Subject: Lancashire County Council - Public Rights of way response to planning app 22/00238/COUR

**22/00238/COUR Wild Boar Farm Rawcliffe Road St Michaels-On-Wyre Lancashire PR3 0UH**

Drawing:  
**Proposed Site Location Plan**

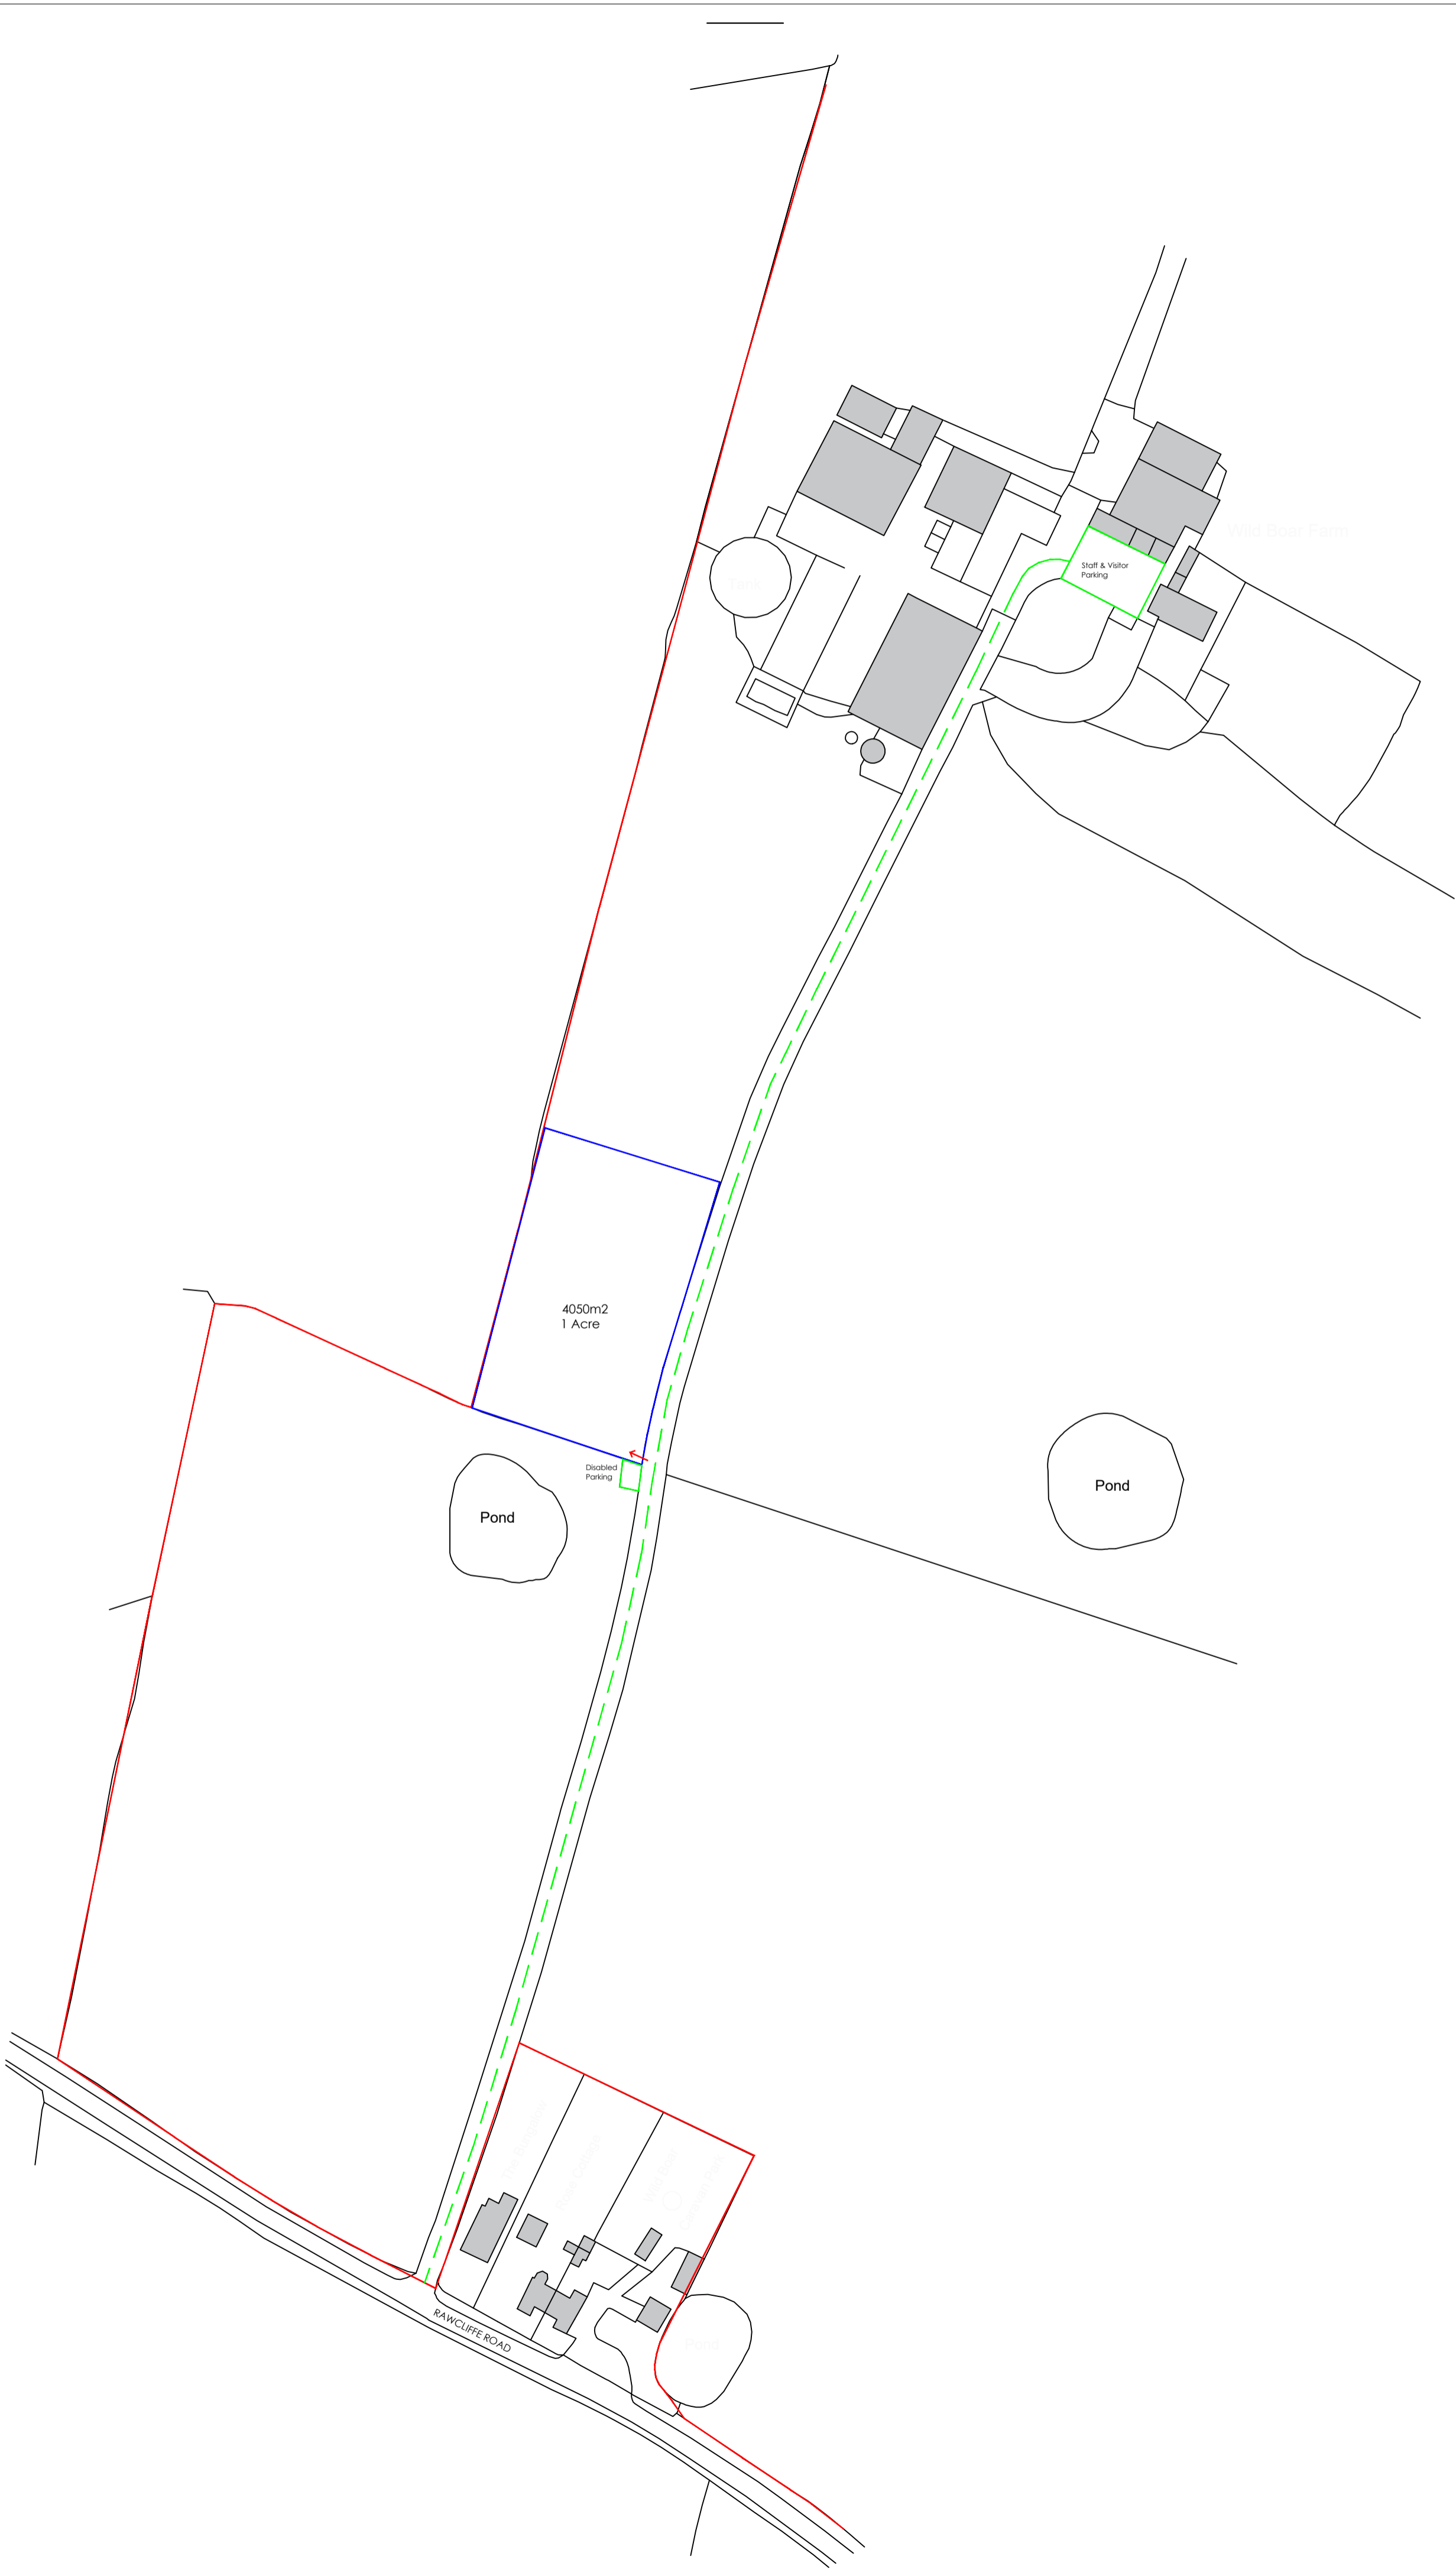
- Public Right of Way 2-23-FP10 runs alongside the proposed access track and to protect users of the footpath a 10 mph speed restriction sign should be erected at appropriate points giving priority to pedestrians
- Any landscaping either within the proposed site or close proximity should be at least 3 metres away from the footpath to ensure overhang or roots growing through the surface of the Right of Way do not create a health and safety hazard e.g. falling branches/trip hazards or future maintenance issues.
